Our Ref: LU/274/21/DOC

Approval of details reserved by condition imposed under ref LU/159/19/PL relating to Condition Nos 8 - materials and finishes, 9 - contamination and 12 - internal noise levels.

2 Croft Cottages Pier Road Littlehampton BN17 5LS

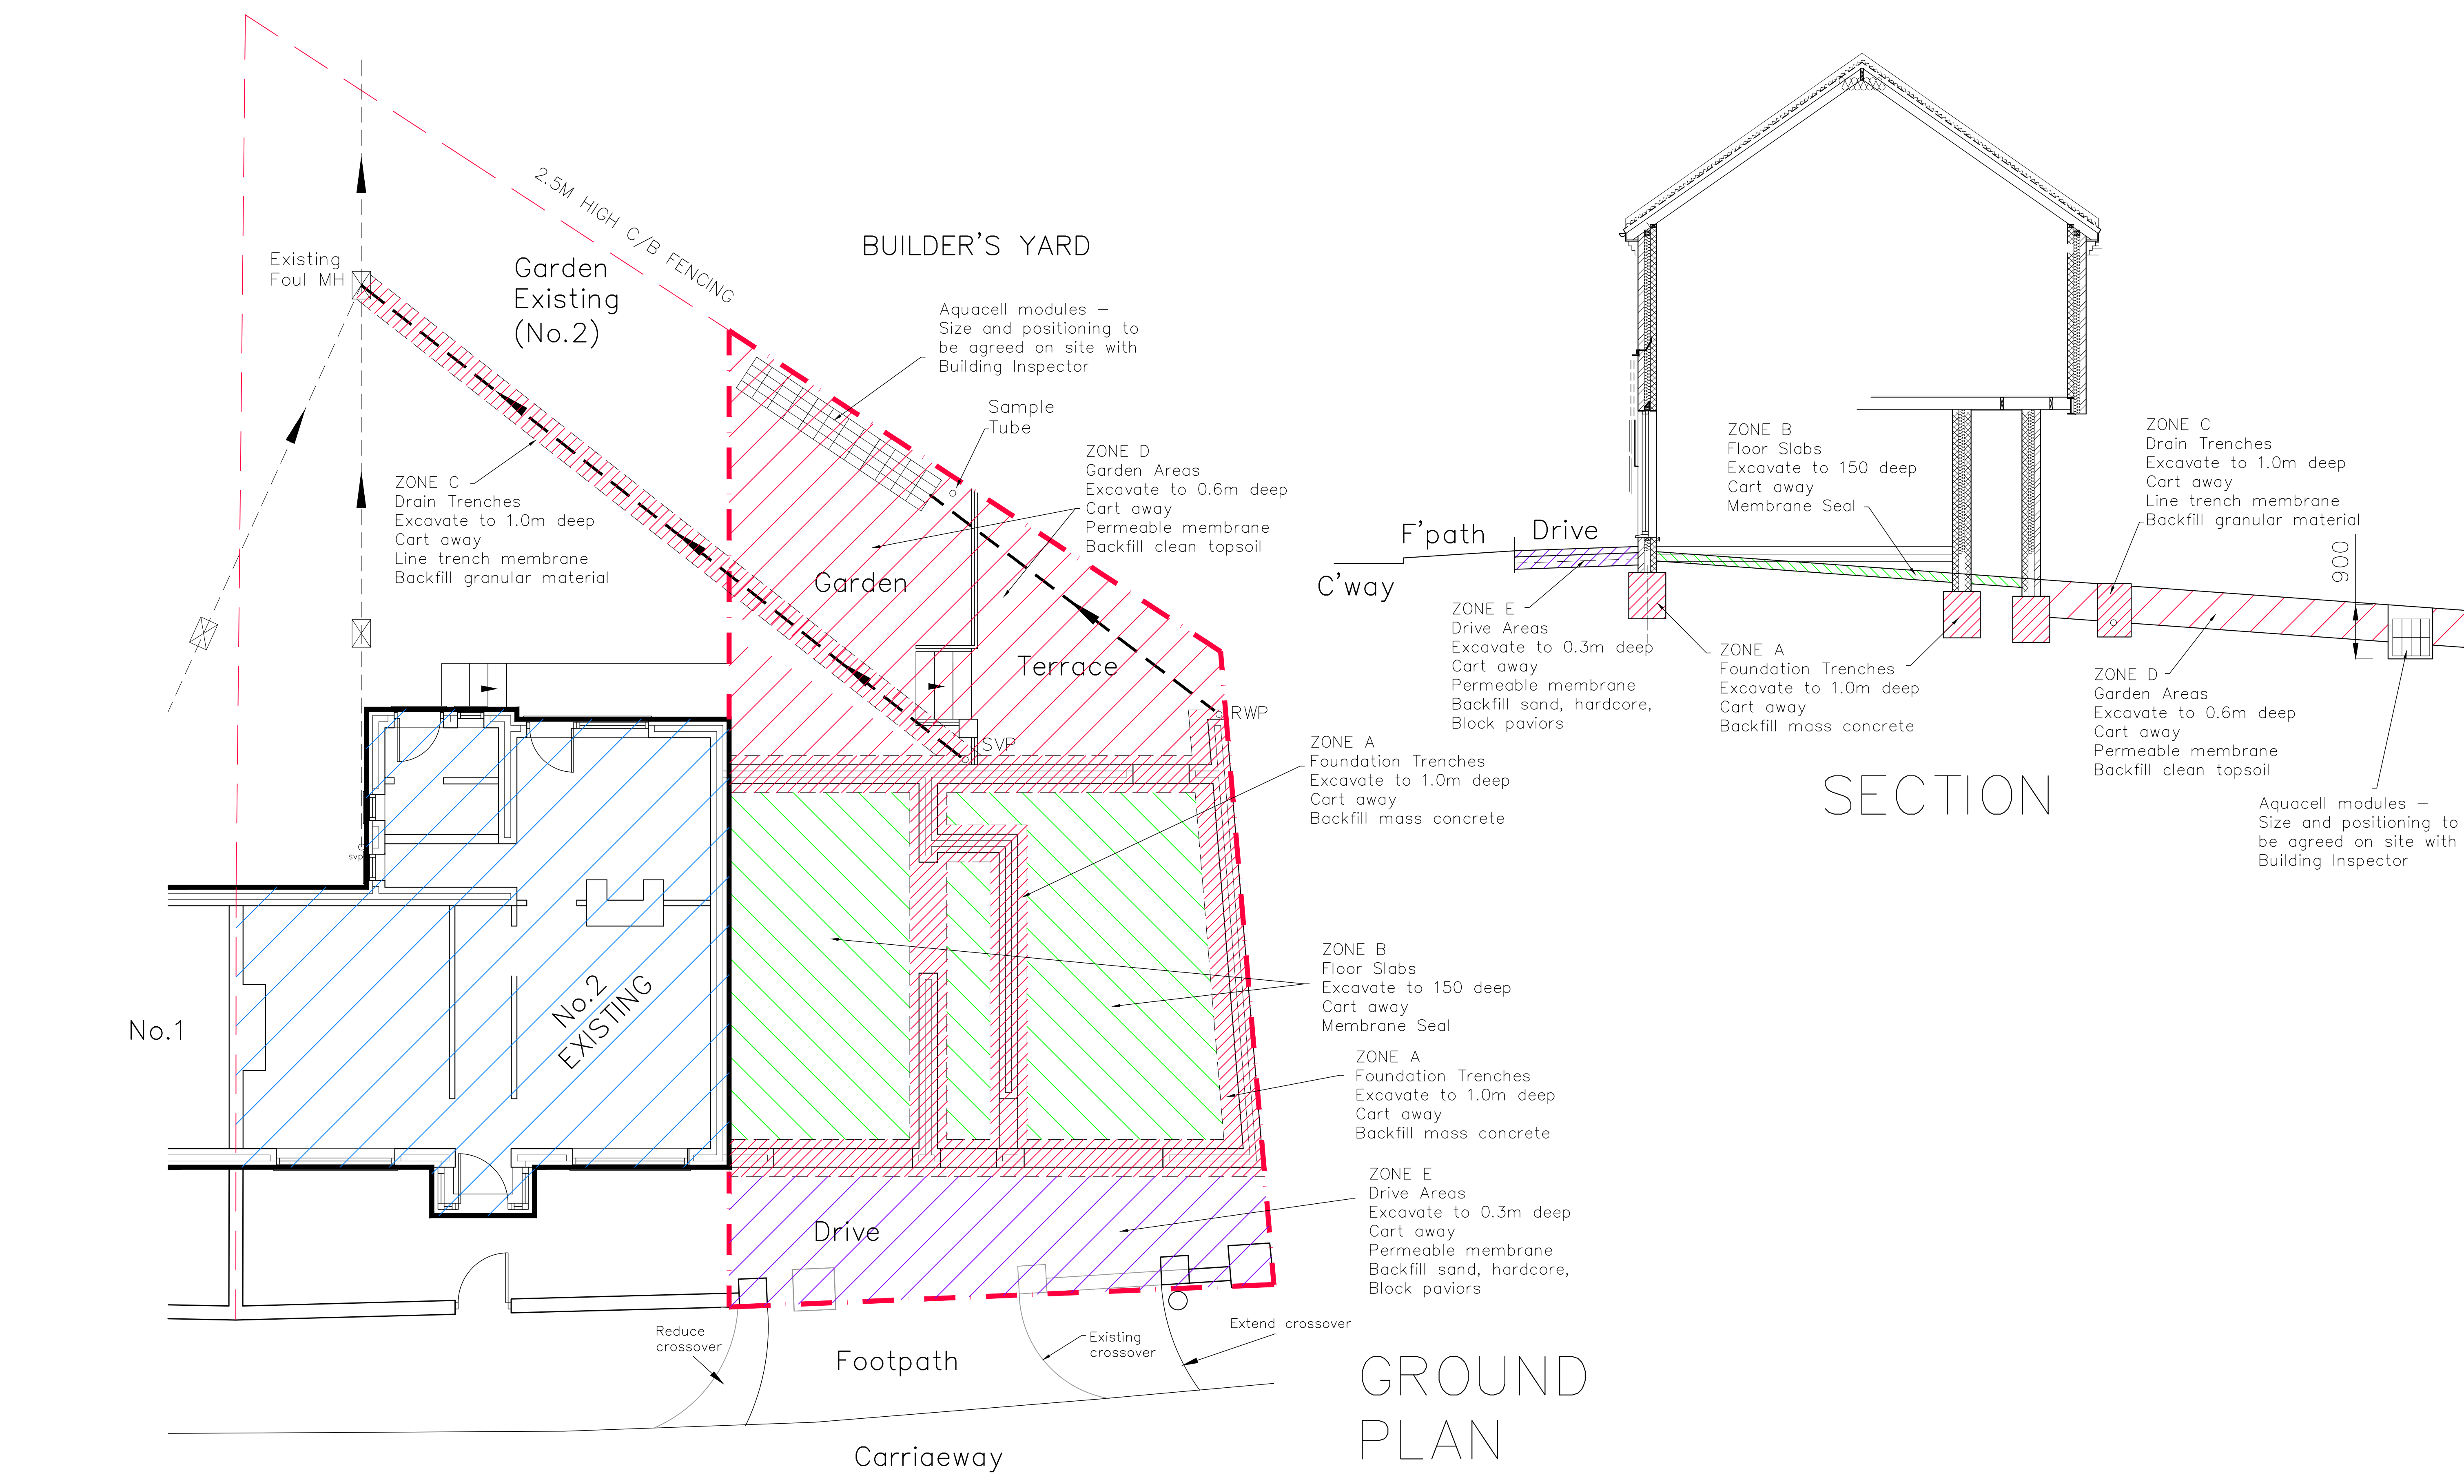
However, EH have confirmed that The Contamination Mitigation Report does not constitute a satisfactory Options Appraisal or Remediation Strategy. It is also recommended that the Environment Agency is consulted with regard to the provision of soakaways (as shown in the Proposed Contamination Containment Plan) in relation to the condition of the land. Therefore parts 3 and 4 of the condition cannot be recommended for discharge at this time. It will not be possible to recommend discharge of the entire condition until a separate Verification Report is provided on completion of groundworks on site (to include soft landscaping). These components of the scheme be submitted to and approved in writing by the LPA prior to commencement of development.
